Environmental Health Division
1675 W. Garden of the Gods Road
Suite 2044
Colorado Springs, CO 80907
(719) 578-3199 *phone*
(719) 578-3188 *fax*
www.elpasocountyhealth.org

Lazy Y RVP, PPR-24-35

Please accept the following comments from El Paso County Public Health regarding the project referenced above:

2 OF 17

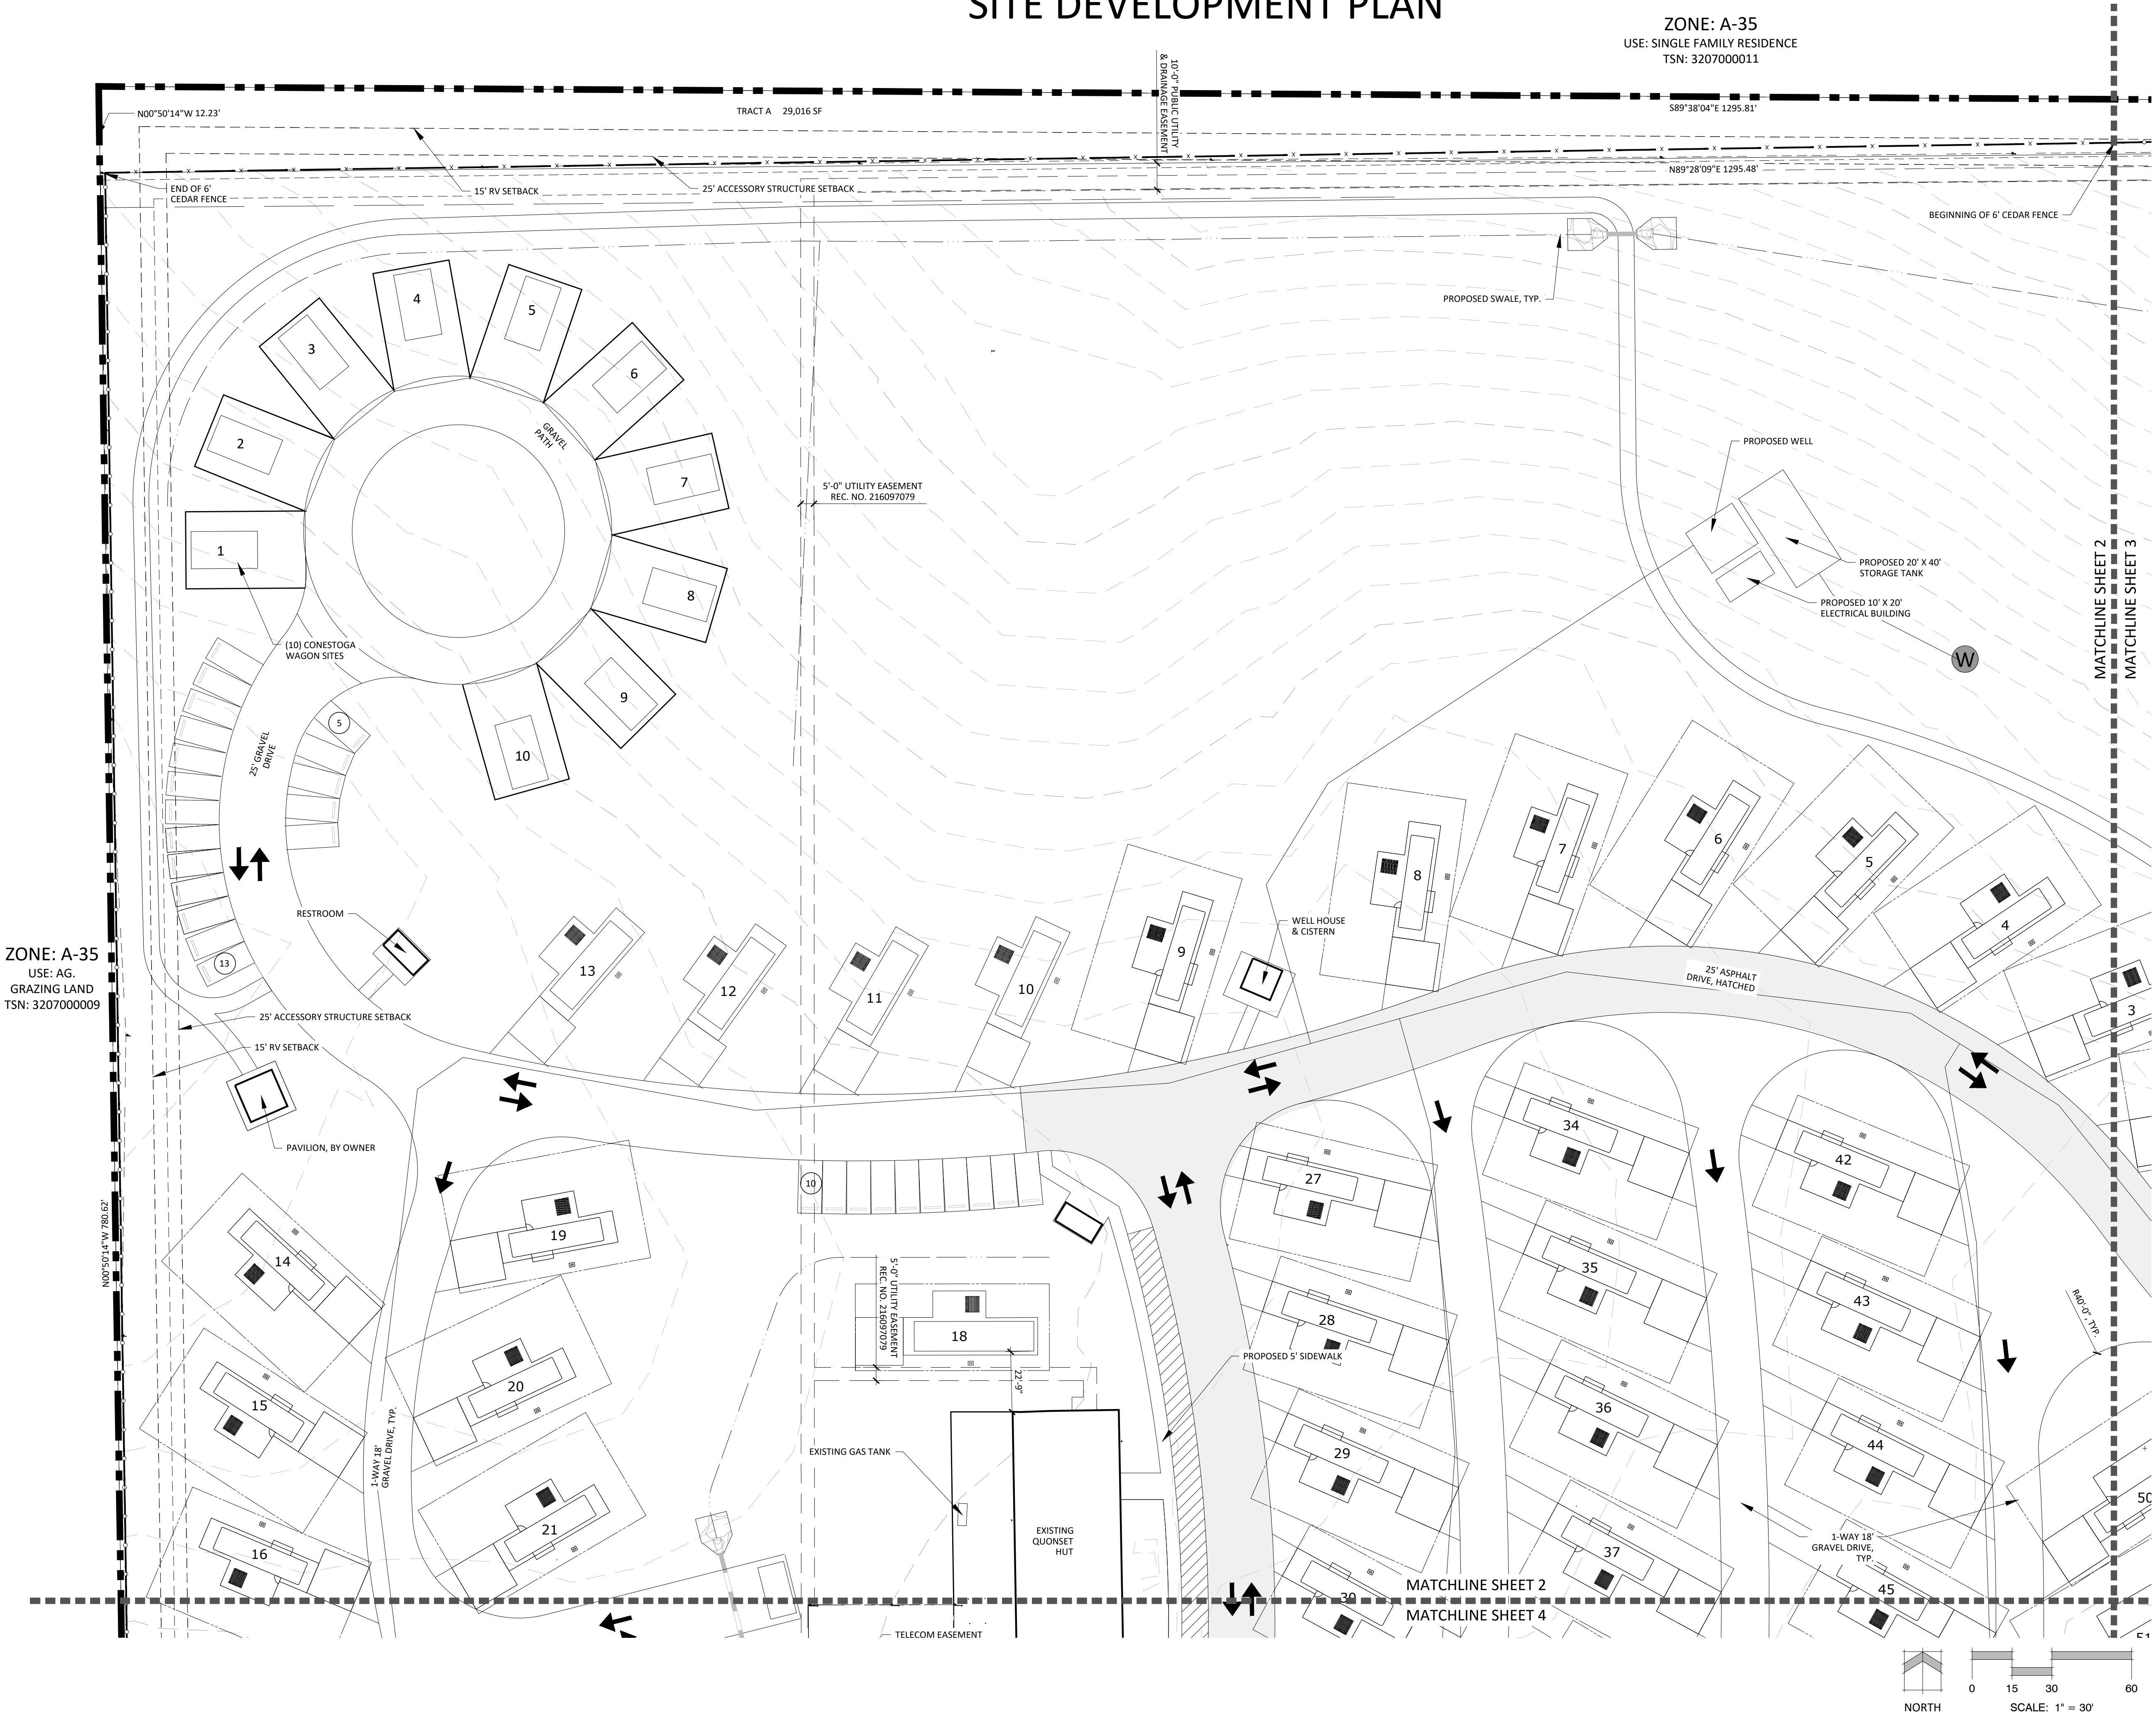
- The proposed RVP soil treatment area (STA) is required to be protected from compaction. It appears the area on the map where the STA for the OWTS is planned may be where two dirt roads used to be located, and soil compaction may be an issue.
